# Appeal Decision

**Appeal Ref: APP/R5510/D/23/3322181**

**11 Court Road, Ickenham, Hillingdon UB10 8TF**

- The application sought planning permission for part single: part two storey side and rear extension (following part demolition of side extension) without complying with a condition attached to planning permission Ref 76354/APP/2021/3284, dated 22 October 2021.

Rev: B. New first floor bathroom have been glazed with Privacy Level 5 obscured Glass. The Applicant has applied to vary the planning condition to allow these windows to have restricted openers fitted to provide natural ventilation whilst retaining privacy. PS.15-02-2023.

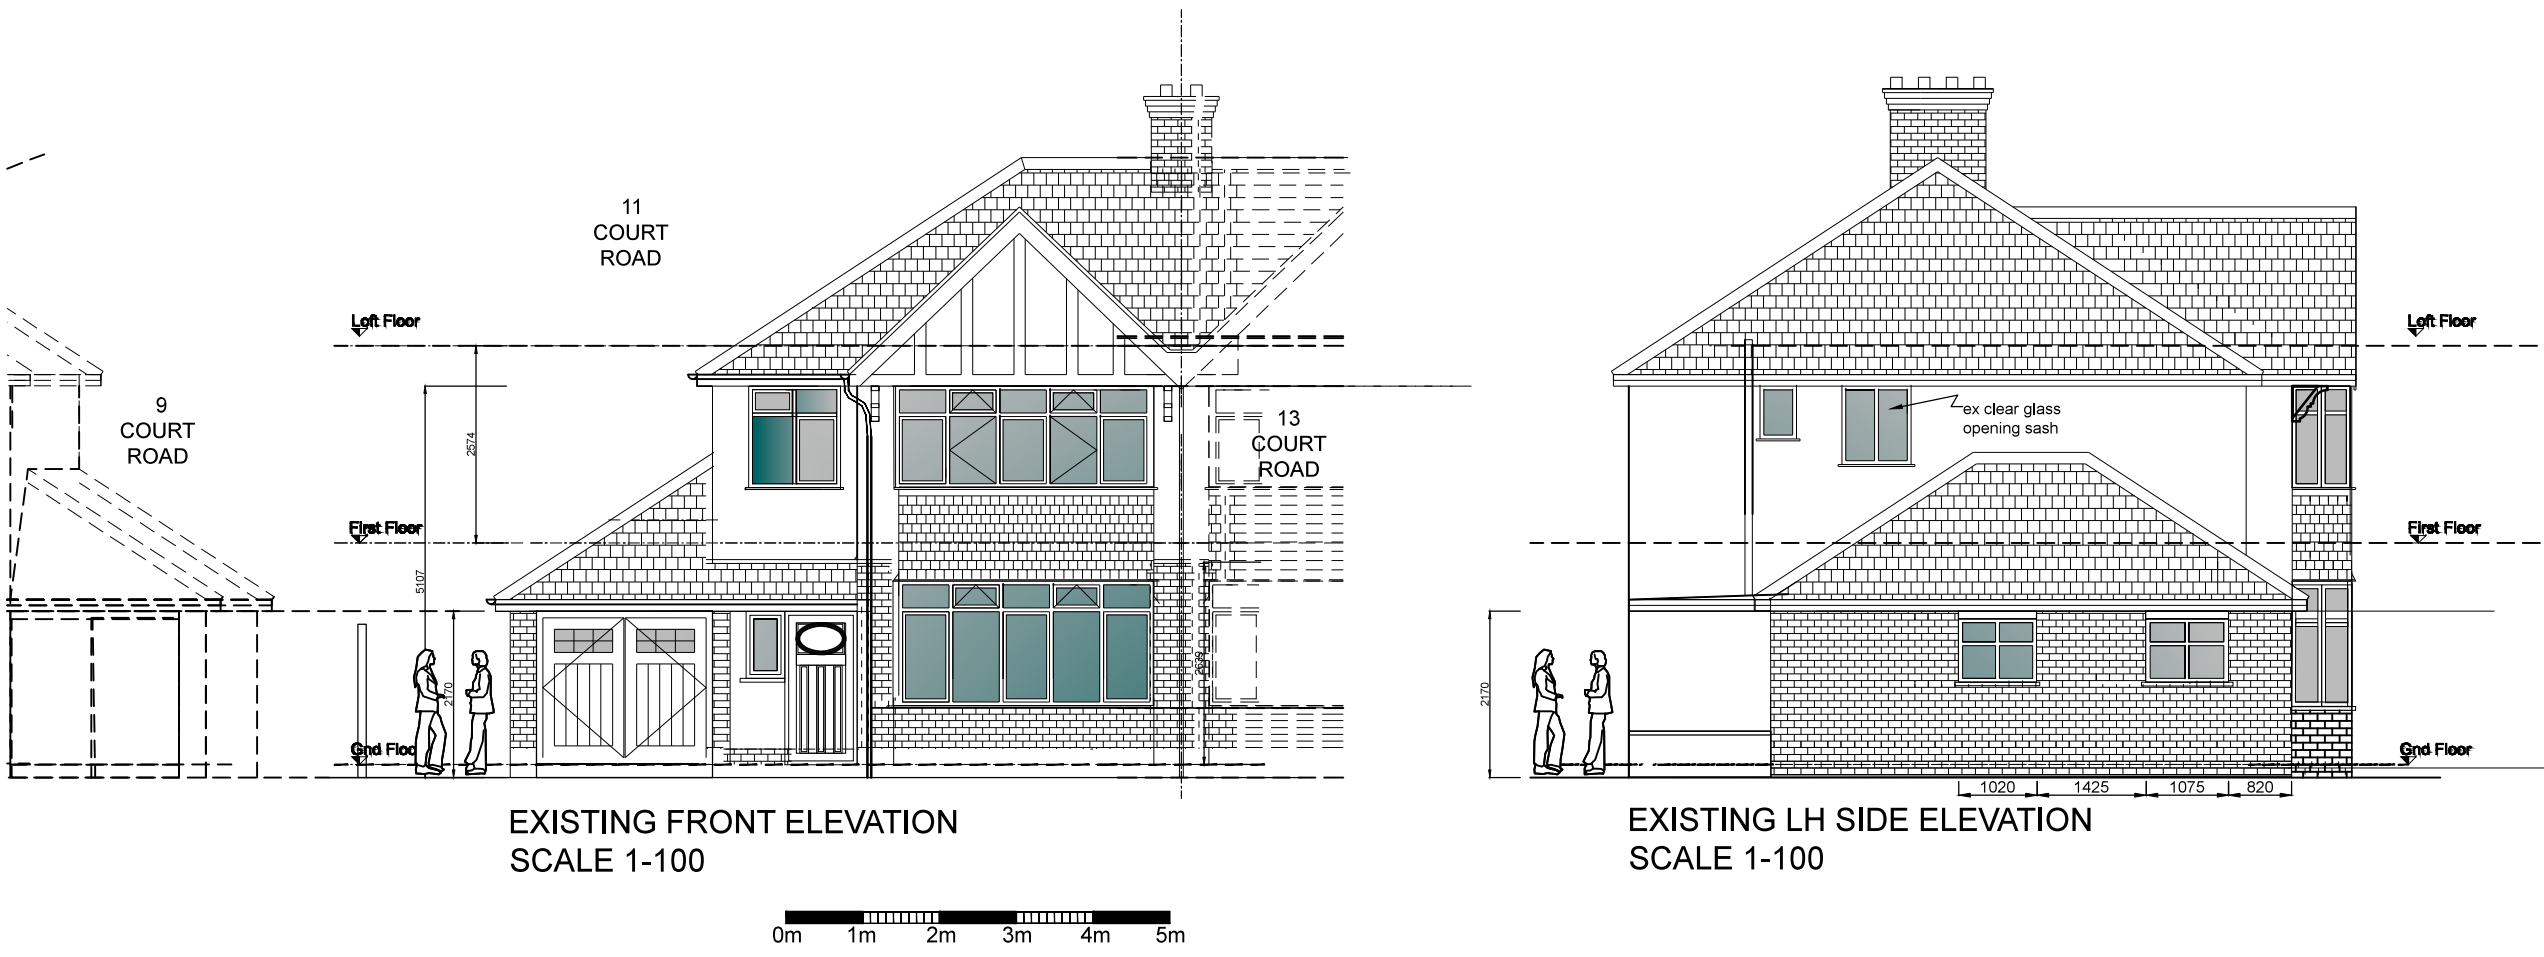
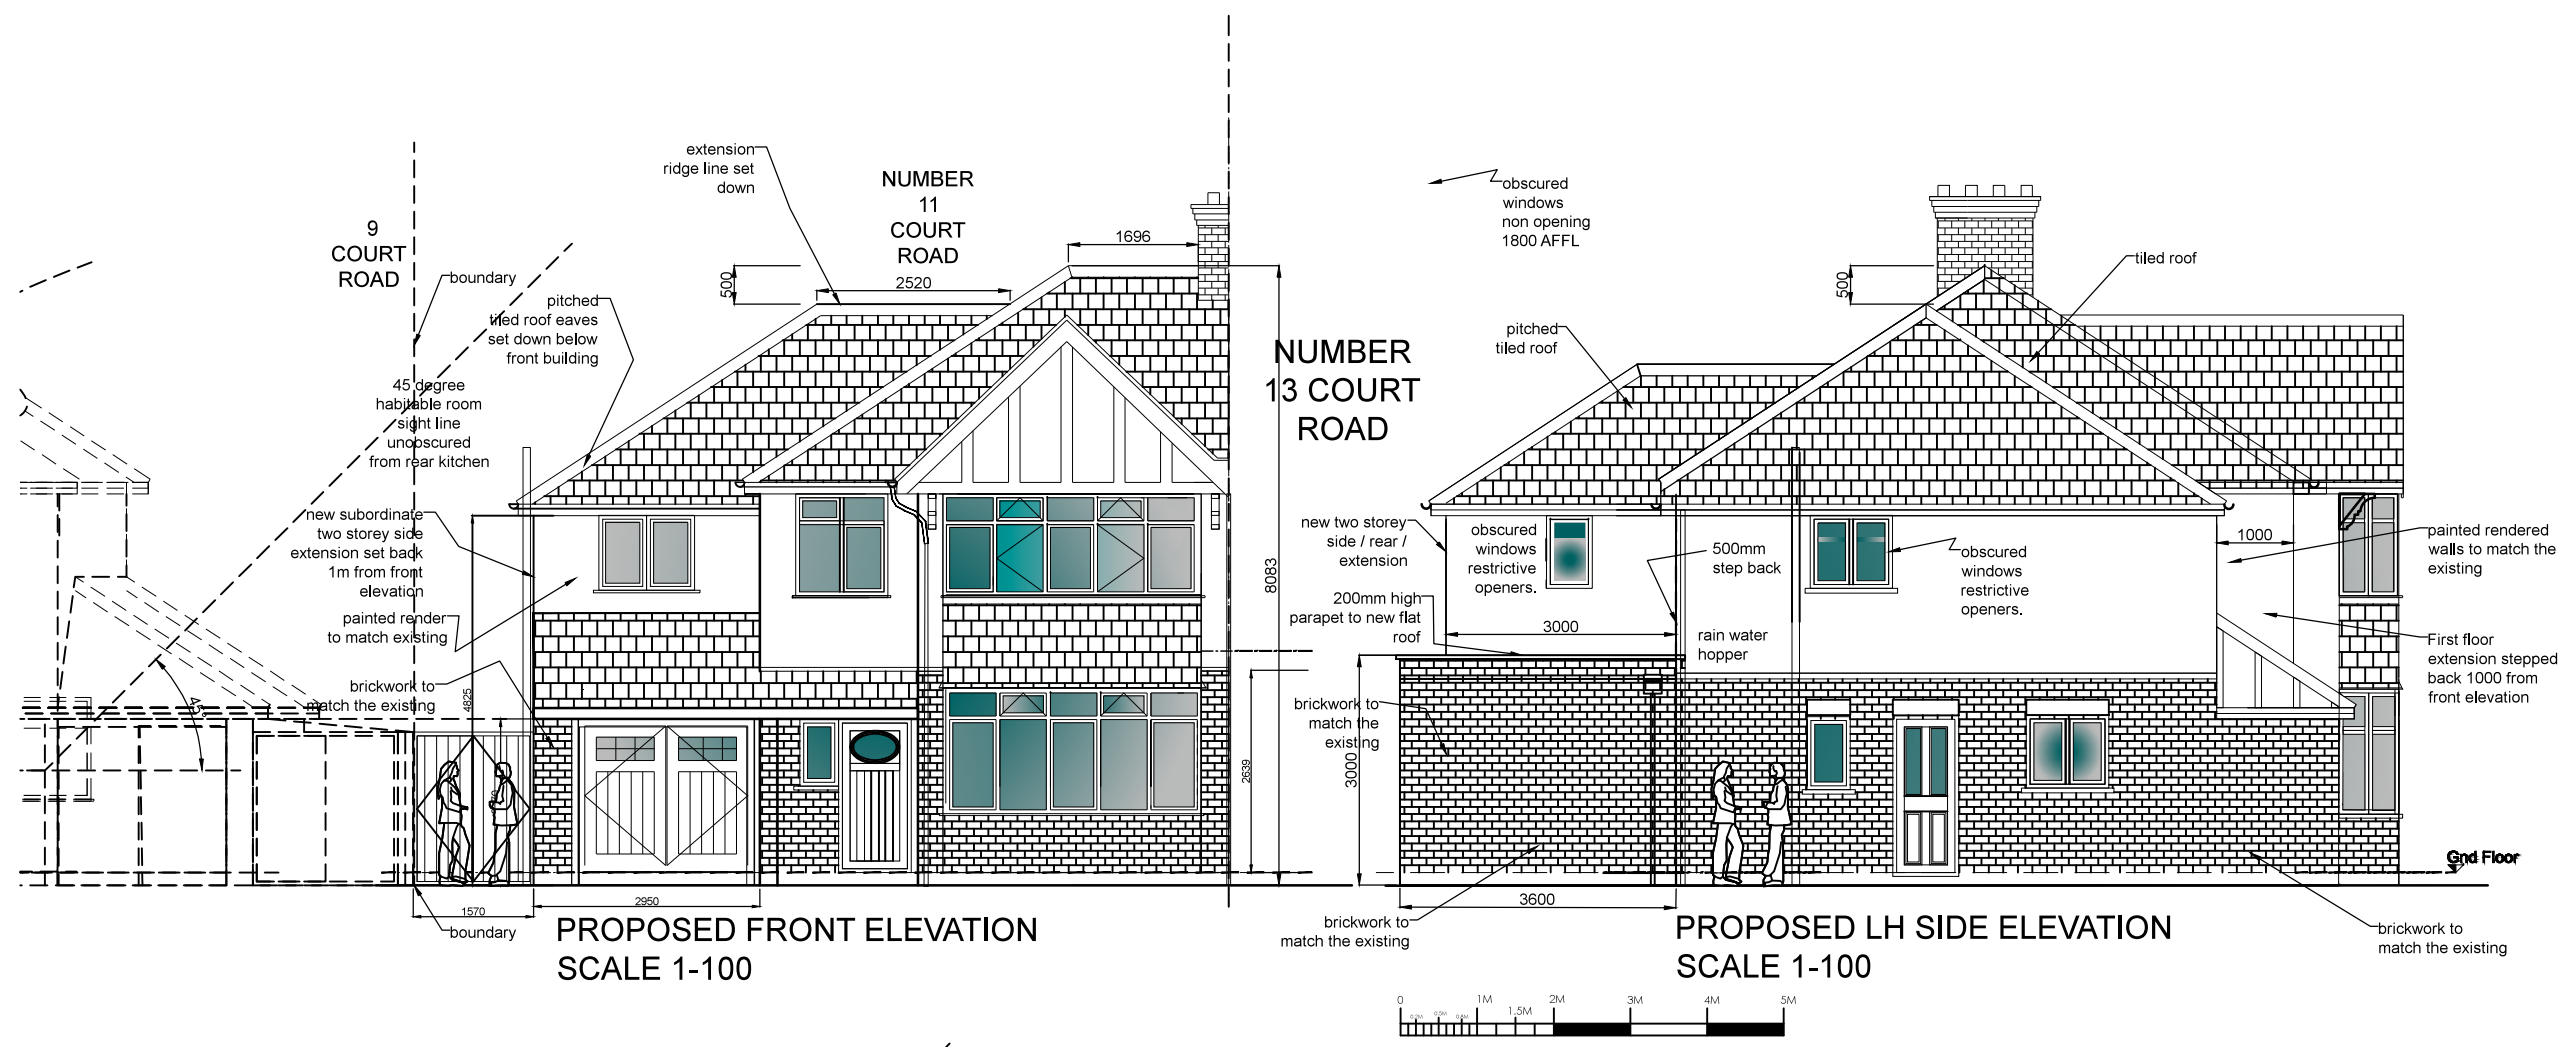
3. The approved works have been completed, including the installation of bathroom and en-suite windows at first floor level of the northern flank elevation facing No 9 Court Road (No 9). The location of the windows is consistent with the approved drawings and they are obscurely glazed. However, the lower part of the windows are openable, contrary to the requirement of Condition 7. They are fitted with restrictors. Following an enforcement complaint, the appellants were invited to retrospectively apply for consent for the windows as installed as a variation to the requirements of Condition 7. That application was refused planning permission and is now the subject of this appeal.

4. The restrictors limit the degree of opening of the windows to about 5cm at the bottom edge. There are constrained and narrow views out from the bottom and along the sides of the windows when they are opened which do not amount to overlooking. The depth of their internal window sills and the location of the bathroom fittings physically prevent looking out of these windows through the small openings. As a result, there is no harmful overlooking of the neighbouring amenity space. From my observations, it would not be possible to override the restrictors.

5. I agree with the Council that full opening of the windows would result in direct and harmful overlooking of the main outdoor amenity space of the neighbouring property. It is therefore reasonable and necessary to impose a replacement condition to permanently retain the restrictors on each of the windows as they prevent any overlooking. Such a condition would enable the Council to take any necessary action in the event that the current or future owners or occupiers of the property enabled the windows to fully open. Accordingly, there would be continued compliance with Policy DMHB 11 of the Hillingdon Local Plan Part 2 (2020).

1. The appeal is allowed and planning permission is granted for part single: part two storey side and rear extension (following part demolition of side extension) at 11 Court Road, Ickenham, Hillingdon UB10 8TF in accordance with the application Ref 76354/APP/2023/451, dated 16 February 2023, without compliance with condition No 7 previously imposed on planning permission Ref 76354/APP/2021/3284, dated 22 October 2021 and subject to the following condition:
  - 1) The first floor bathroom and ensuite windows in the elevation facing No.9 Court Road shall remain glazed with permanently obscured glass to at least scale 4 on the Pilkington scale (or the nearest equivalent standard) and shall have a restricted opening system allowing a maximum opening of 5cm. The windows shall be retained in that form thereafter.

6. For the reasons given above and having regard to all other matters raised, I conclude that the appeal should be allowed with a varied condition requiring the subject windows to remain obscurely glazed and their opening restricted, in order to protect the privacy of neighbouring residents. As the development is substantially complete, there are no remaining conditions from the original permission that need to be reimposed.
